**WELWYN HATFIELD BOROUGH COUNCIL
EXECUTIVE DIRECTOR - PLANNING, PUBLIC PROTECTION AND GOVERNANCE**

Application No: 6/2022/1252/LAWP
Location: 75 Pine Grove Hatfield AL9 7BL
Proposal: Certificate of Lawfulness for the erection of an outbuilding to accommodate a swimming pool
Officer: Mrs Kerrie Charles

Recommendation: Refused

DRWG N°: **1171/LD/002**

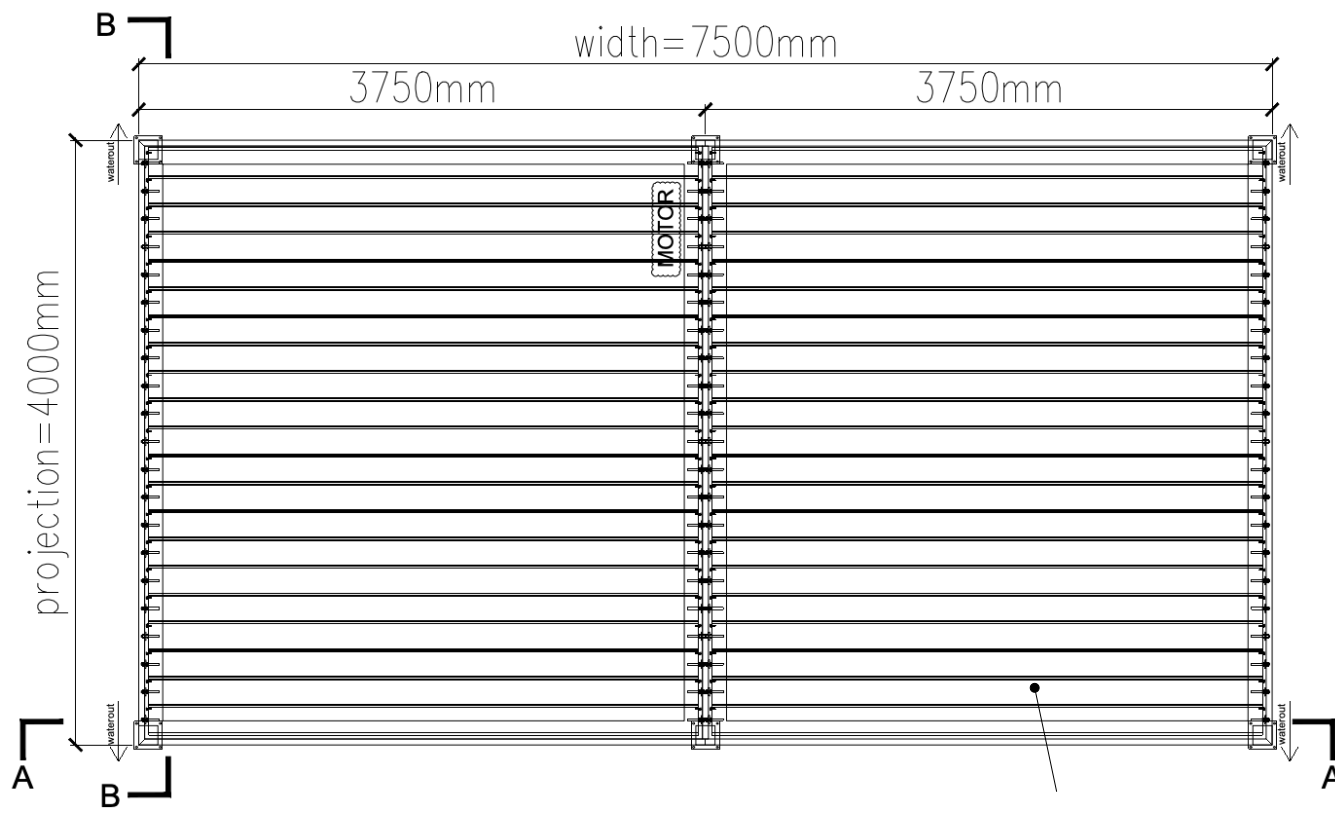
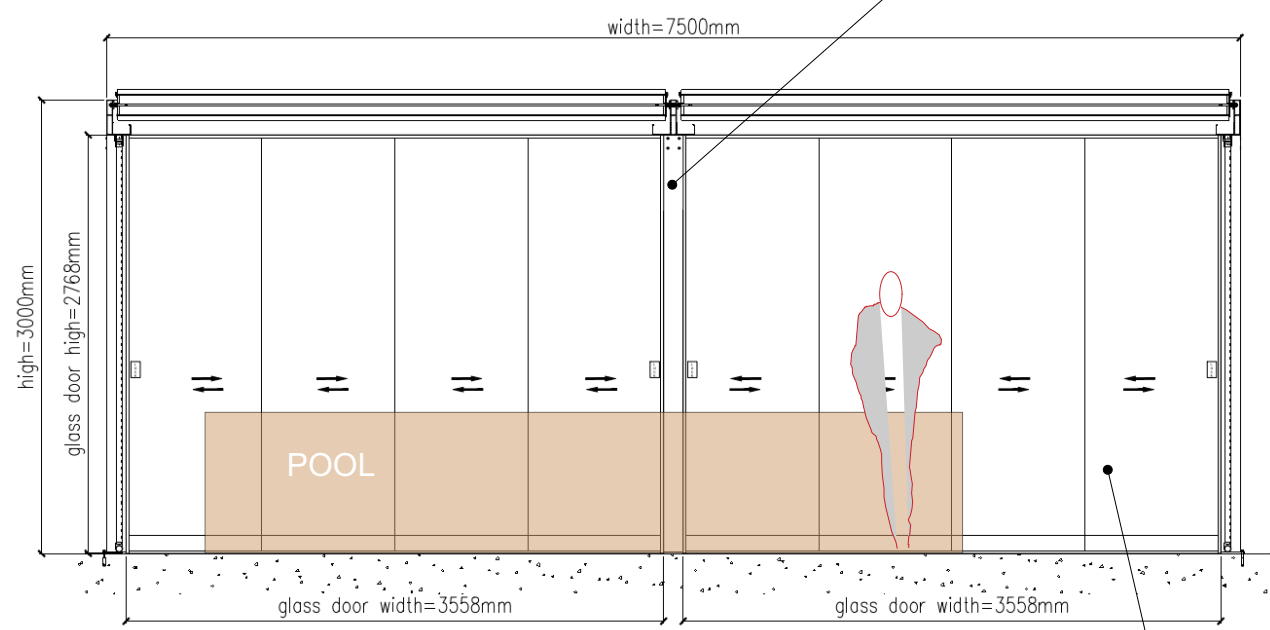
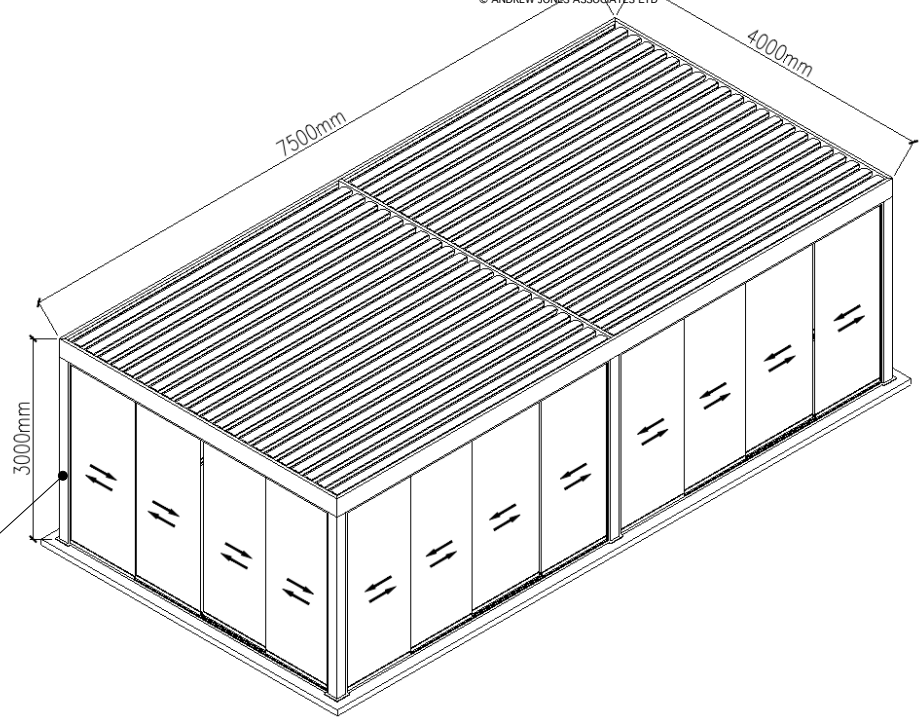
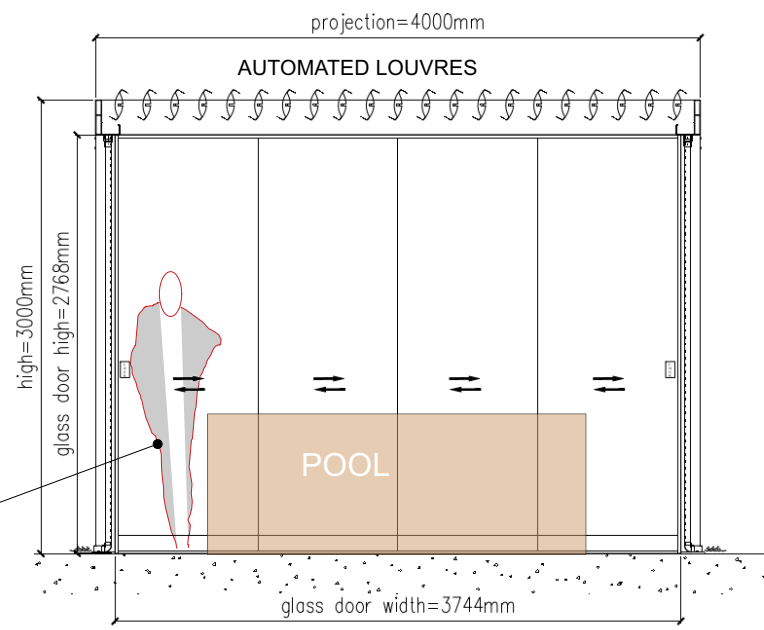
(f) the height of the eaves of the building would exceed 2.5 metres;	Y	N
(g) the building, enclosure, pool or container would be situated within the curtilage of a listed building;	N	N

(j) the capacity of the container would exceed 3,500 litres.	N	N
E.2 deliberately excluded		
E.3 In the case of any land within the curtilage of the dwellinghouse which is article 2(3) land, development is not permitted by Class E if any part of the building, enclosure, pool or container would be situated on land between a wall forming a side elevation of the dwellinghouse and the boundary of the curtilage of the dwellinghouse.	N	N
Discussion		
The eaves of the proposed building will be more than 2.5m in height, therefore would not be permitted development.		
Conclusion		
The proposed works are NOT permitted development by virtue of Schedule 2, Part 1, Class E of the Town and Country Planning (General Permitted Development) (England) Order 2015 as amended by virtue of the proposed eaves exceeding 2.5m in height.

1. The proposed works are NOT permitted development by virtue of Schedule 2, Part 1, Class E of the Town and Country Planning (General Permitted Development)

(England) Order 2015 as amended by virtue of the proposed eaves exceeding 2.5m in height.
